Plat Name Hansen Short Plat

File Number JP-94-16 Date Received 5-27-94

Bob Hansen Short Plat  
SP-94-16

**RE: Bob Hanson Short Plat**

PARCEL NO. 22-11-1133-0001

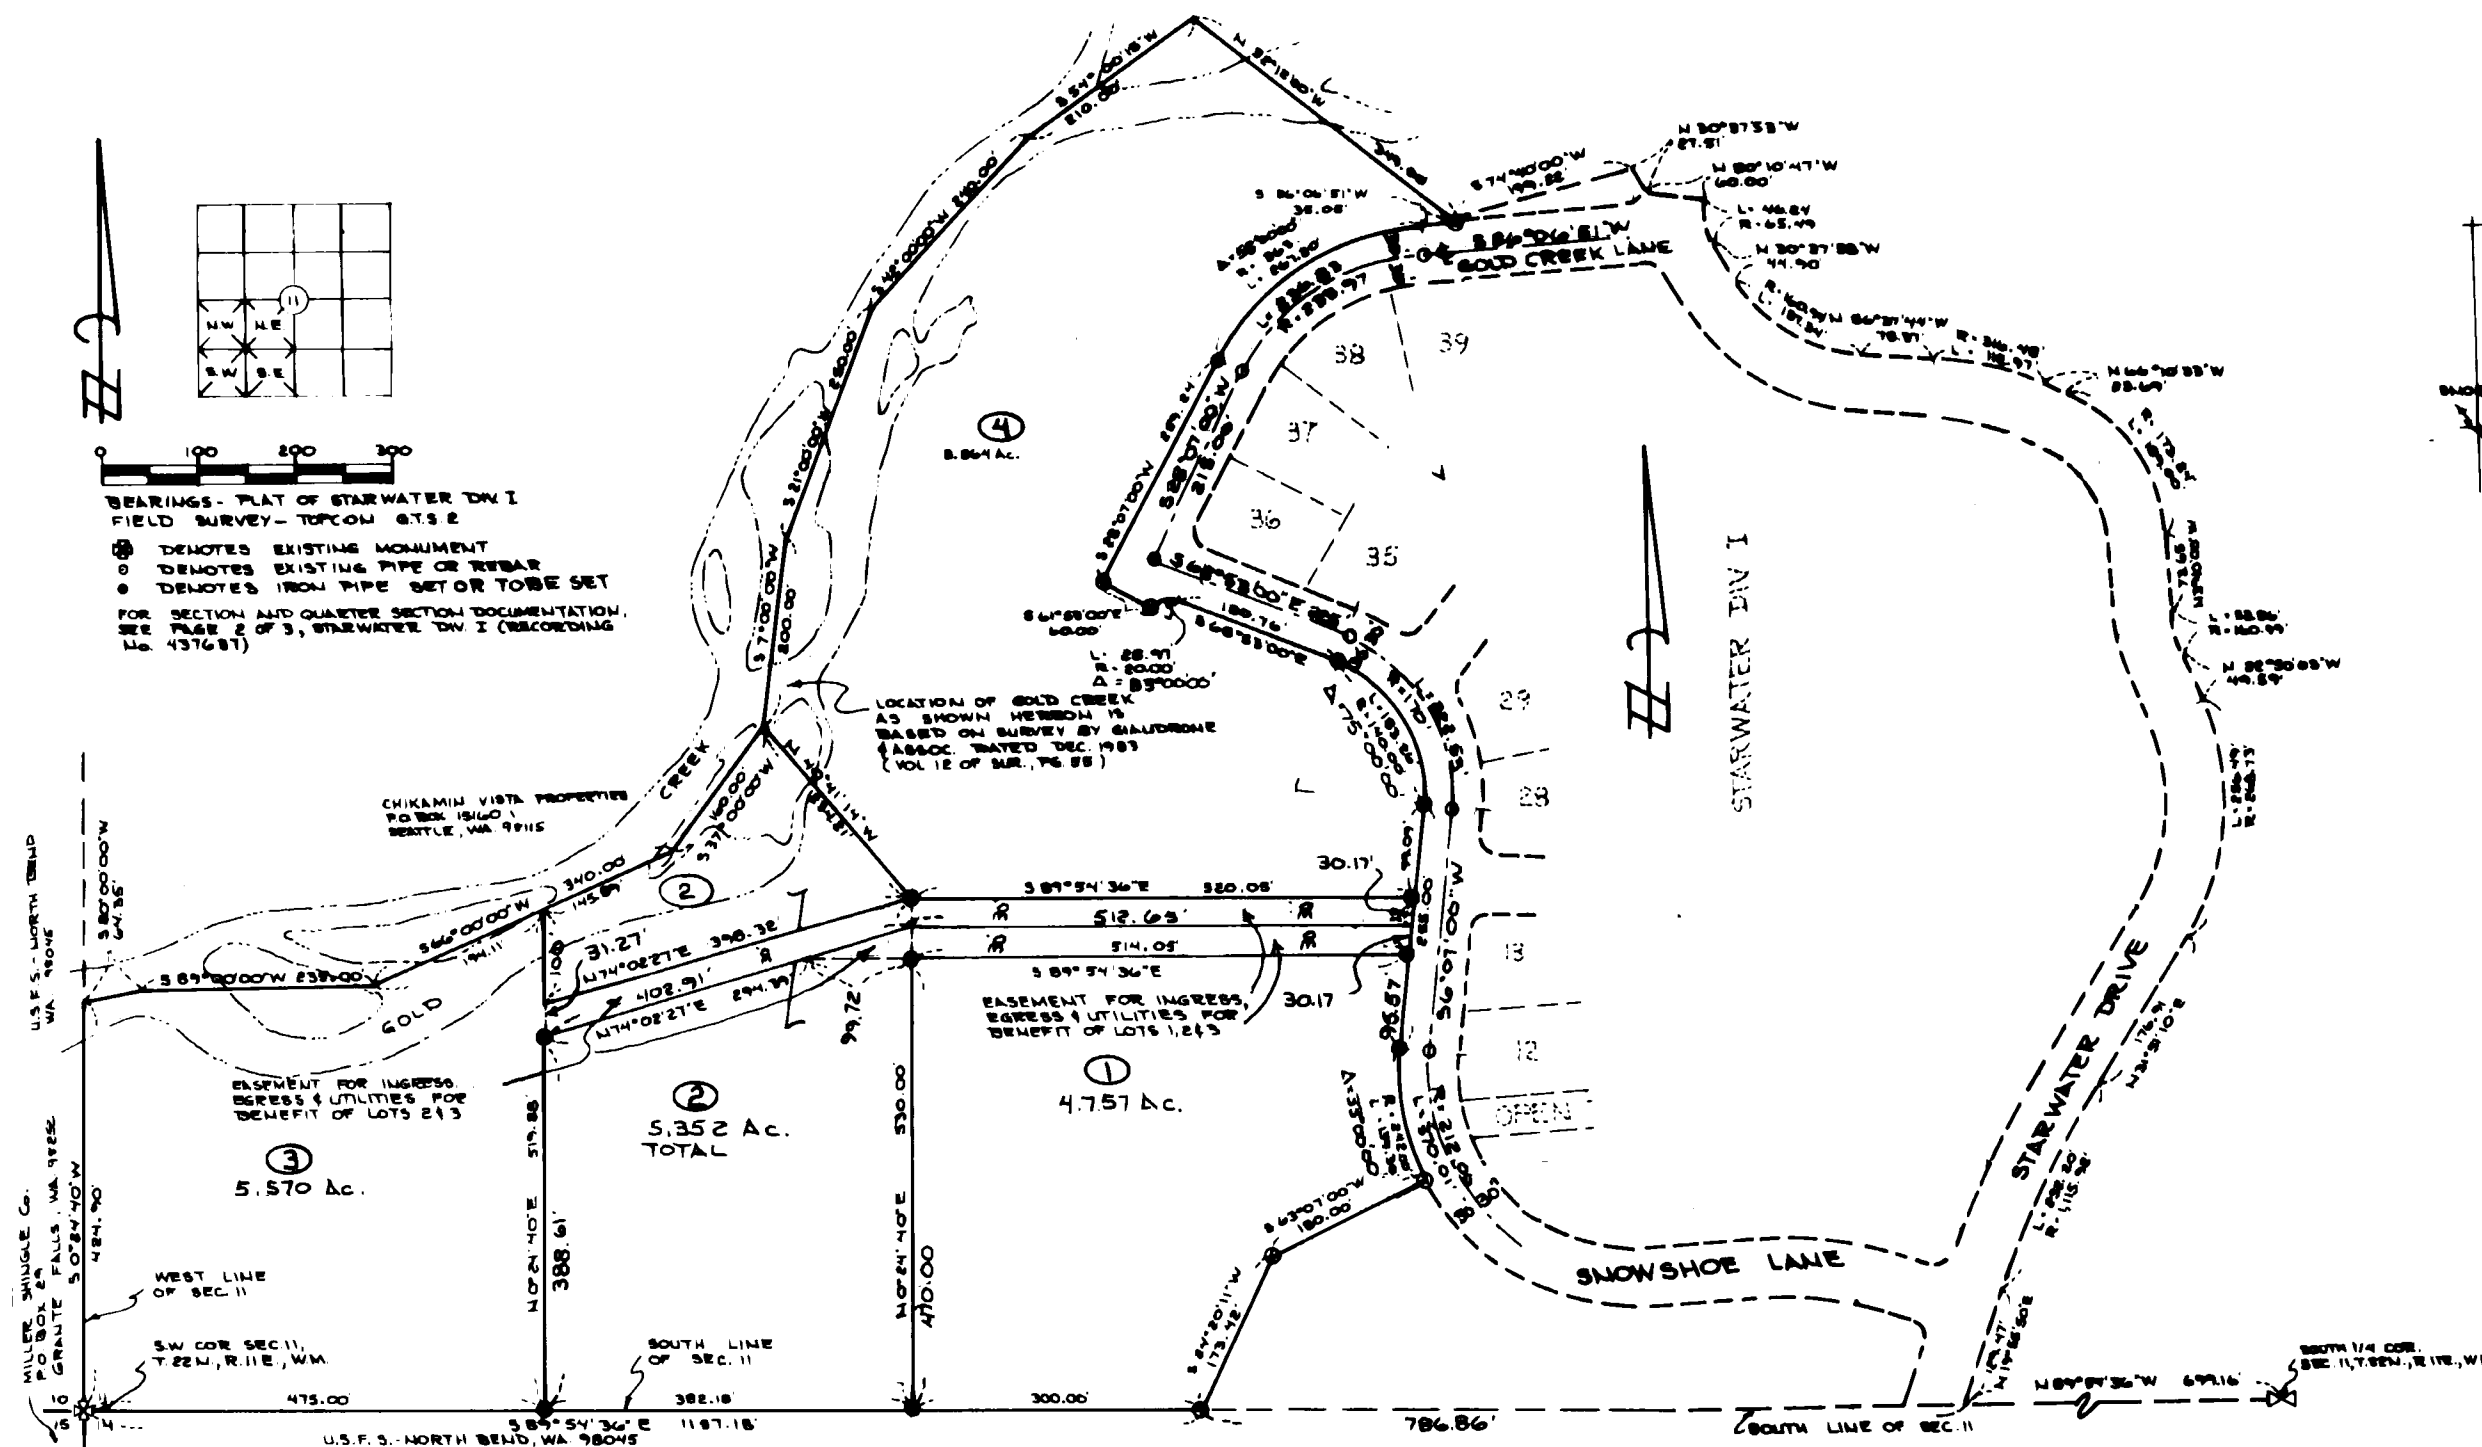
1. All lots shall abut the public right-of-way. Lot reconfiguration should resemble the enclosed penciled flagstems.
2. Computer Sheets shall be submitted with the final short plat.

3. Appropriate utility easements must be disclosed according to code on the face of the short plat. An explanatory note may also be added on page two. Such notes should also explain access provisions.

4. The final short plat's scale shall be 1"=200'.
5. A space for recording and receiving numbers shall be reserved and appropriately labeled in the upper right hand corner of the short plat.

6. The centerline of all roads shall be established and delineated on the face of the short plat.
7. Approval certification blocks shall be depicted on the face of the short plat.

8. The dedication shall state that ".....all roads, streets, avenues, places or whatever public property shown hereon which shall be maintained by the individual property owners".
